OBSERVATION/SUBMISSION TO PLANNING APPLICATION

Case Reference: 324113

Re: Observation to the proposed development of open-cycle gas turbine (OCGT) and generator with ancillary equipment.

Location: Pollnagroagh and Rathmorrissy (Townlands), Athnery, Co. Galway

Purpose		PLANNING			
Title		SITE ACCESS SIGHTLINES			
Original Scale	Design/Drawn	Checked	Authorised		
SHOWN at A1	PS	ND	AJB		
Date	Date	Date	Date		
01.12.25	01.12.25	01.12.25	01.12.25		
Status	Drawing Number	Rev			
A2	PEK3-ATK-ZZ-01-DR-CE-901200	0

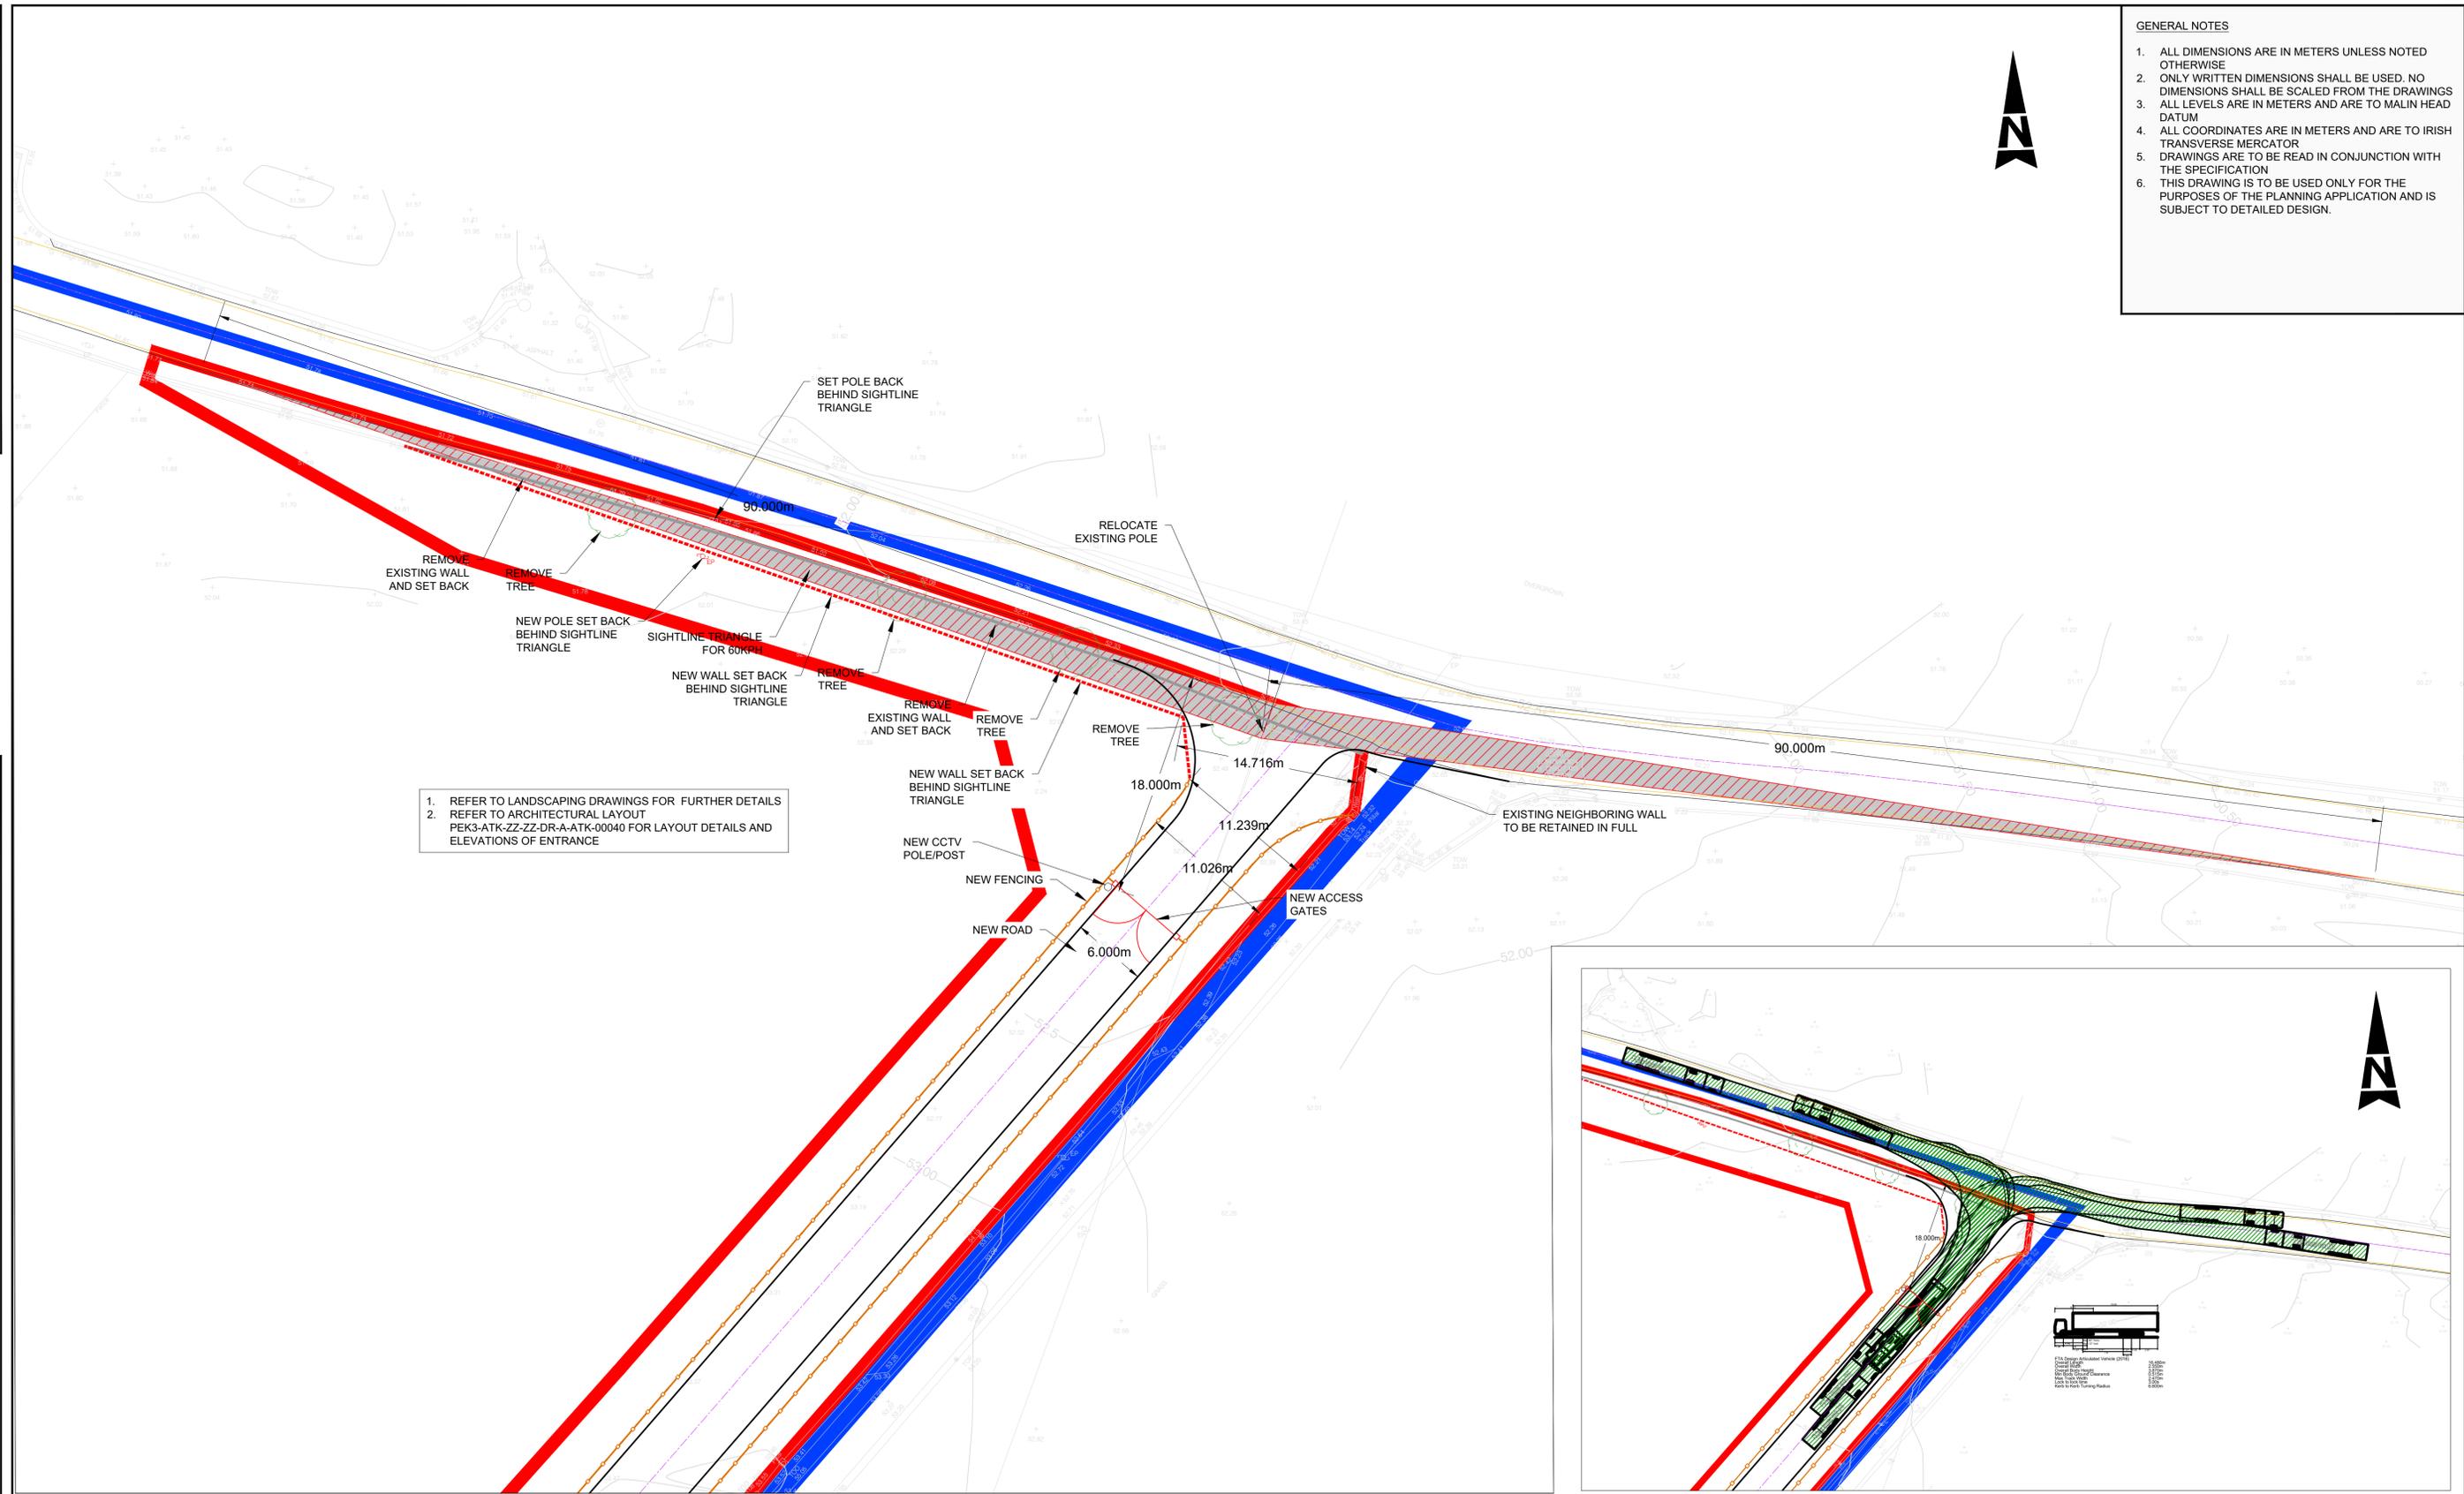
The placement of the proposed site entrance on the L3103 raises severe safety concerns due to the inherently hazardous nature of this specific stretch of road. The carriageway is critically narrow, struggling to safely accommodate two passing Heavy Goods Vehicles (HGVs), and completely lacks a hard shoulder to allow for any margin of error. Compounding these dangers are the presence of blind dips and corners, which significantly reduce visibility and sightlines for all road users. These critical safety deficiencies create an unacceptable traffic hazard that must be comprehensively addressed.
